KITITAS COUNTY

MEMORANDUM

TO: All Staff
FROM: Public Works Plan Review Team
DATE: April 27, 2022
SUBJECT: BL-22-00010 Miller

The Public Works Department has reviewed the Request for Boundary Line Adjustment Application.

2
1.18 AC

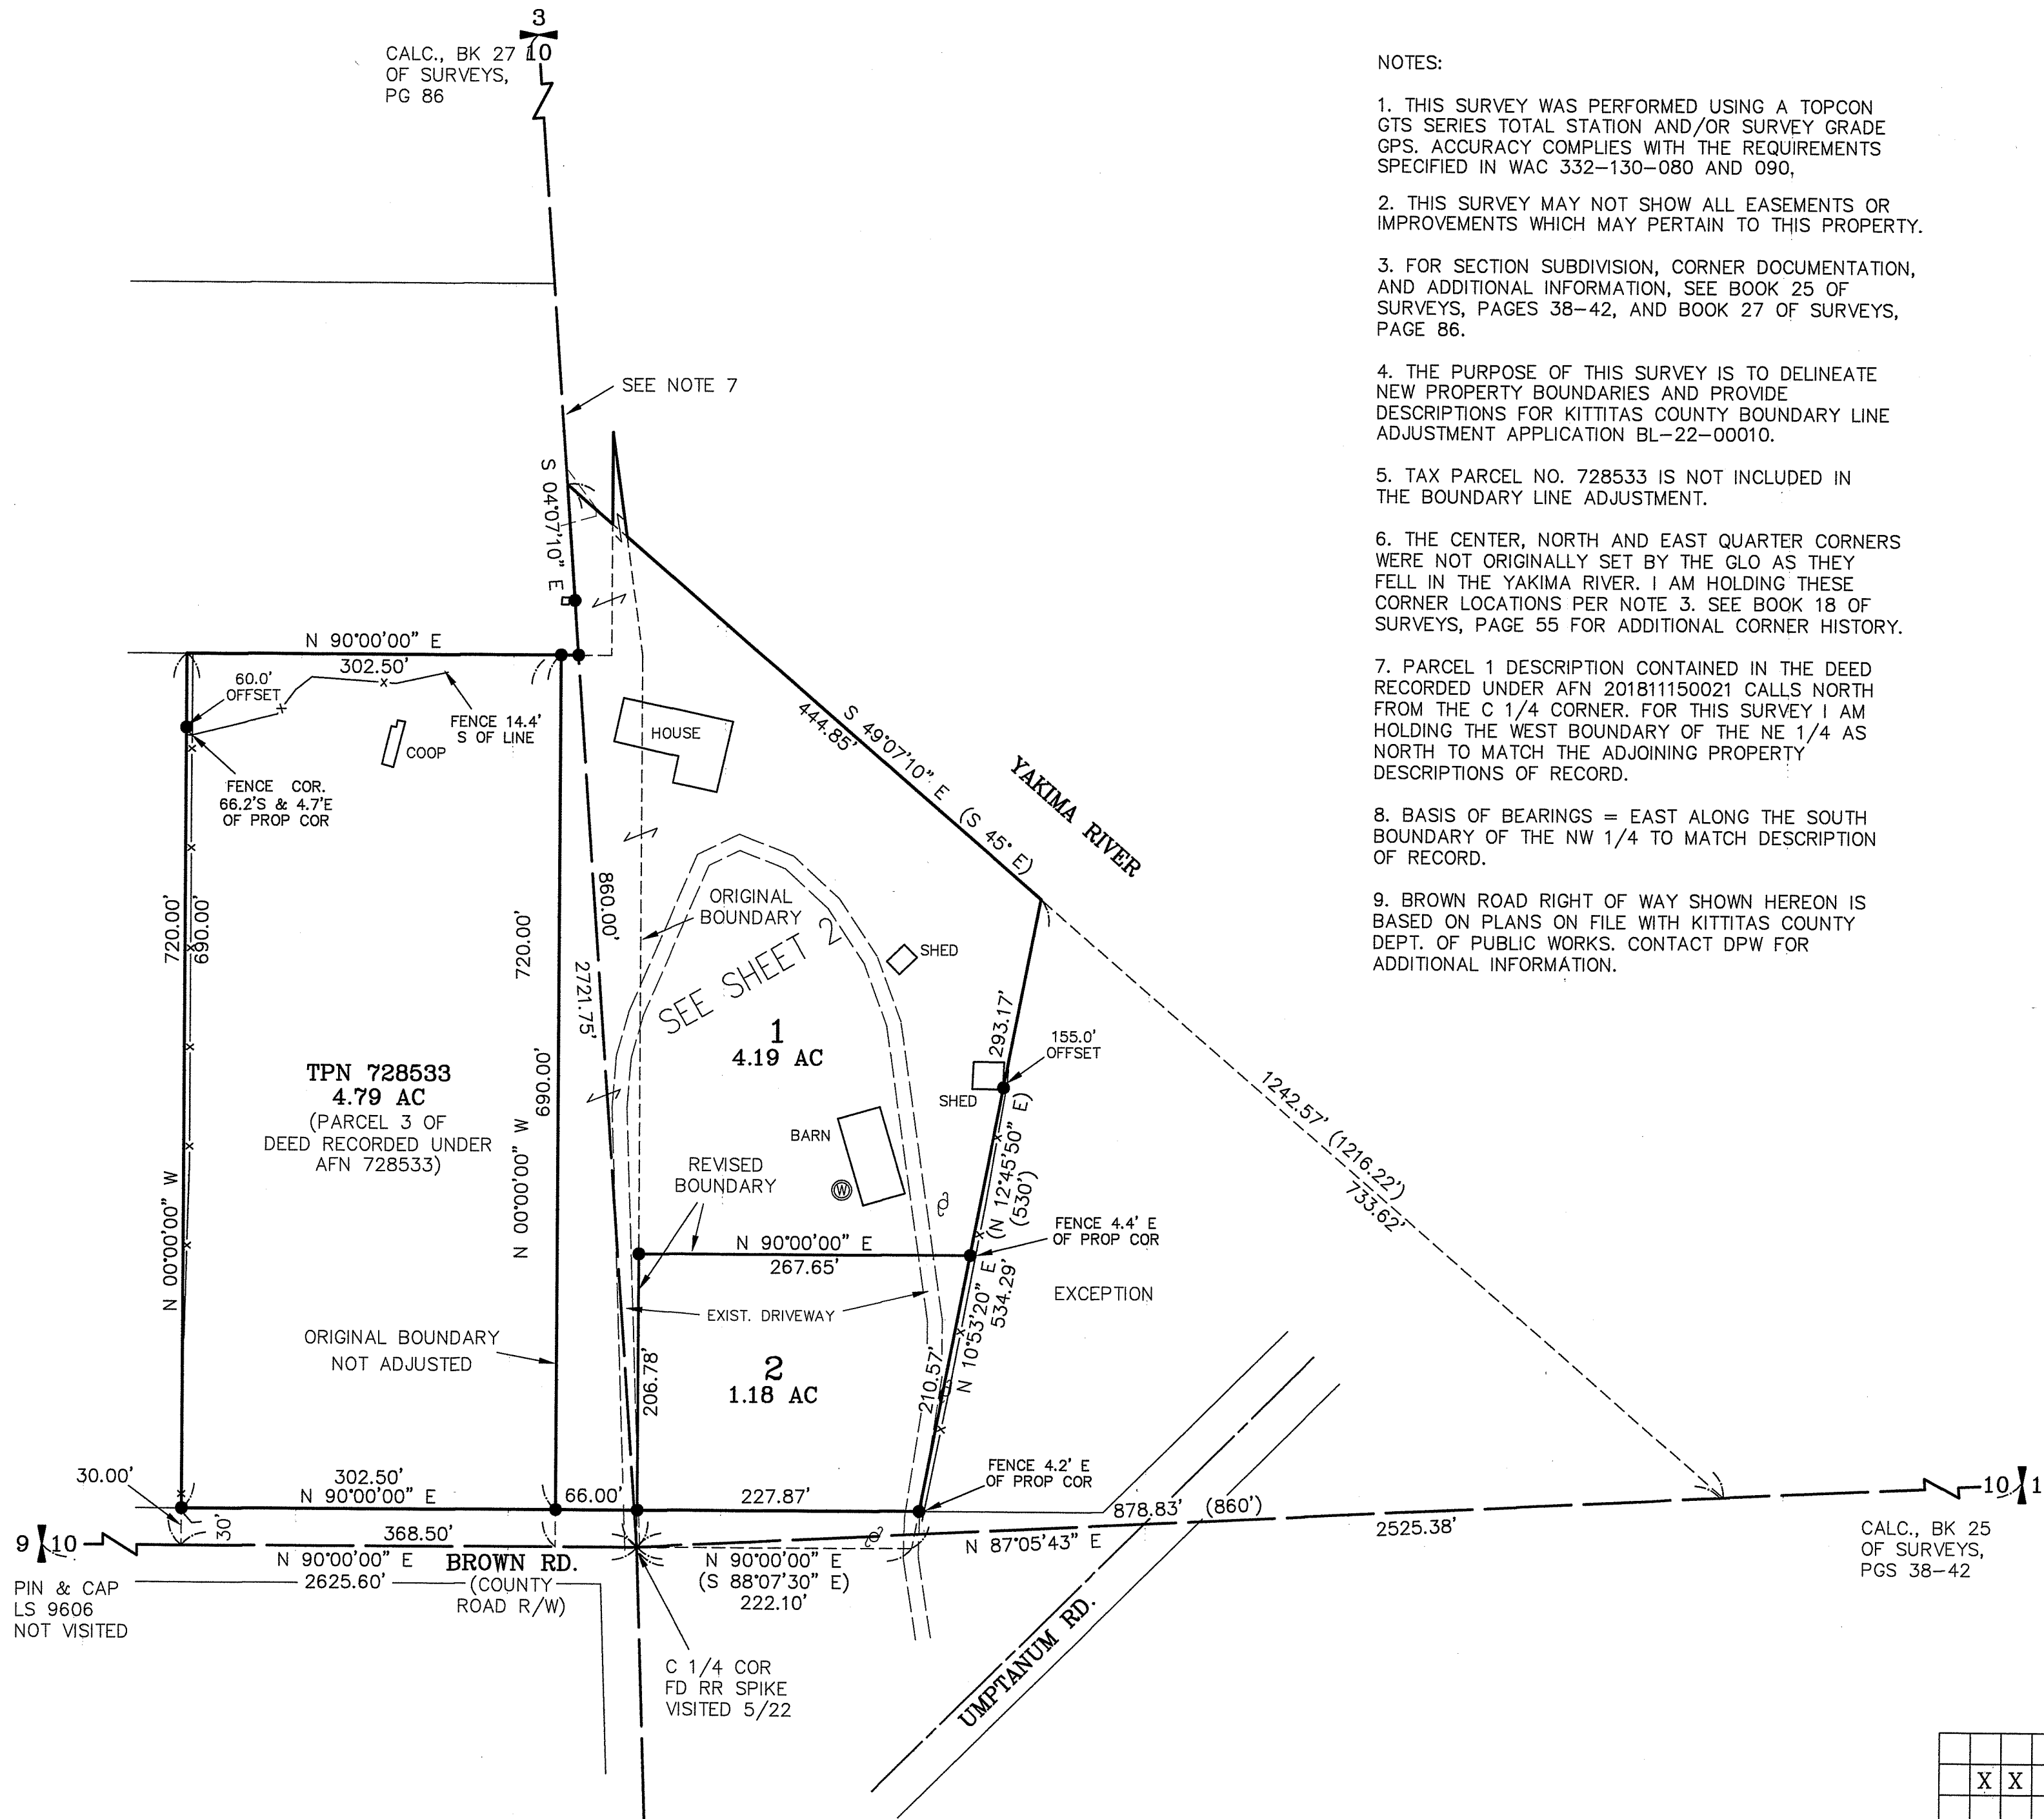
- a. The new parcel labeled as 1.18 AC will relocate the property boundary directly next to both existing driveways. No driveway or road shall be constructed within five feet of the side yard boundary, unless the driveway or road is part of an easement shared with the neighboring property owner. (KCC 12.05.080)
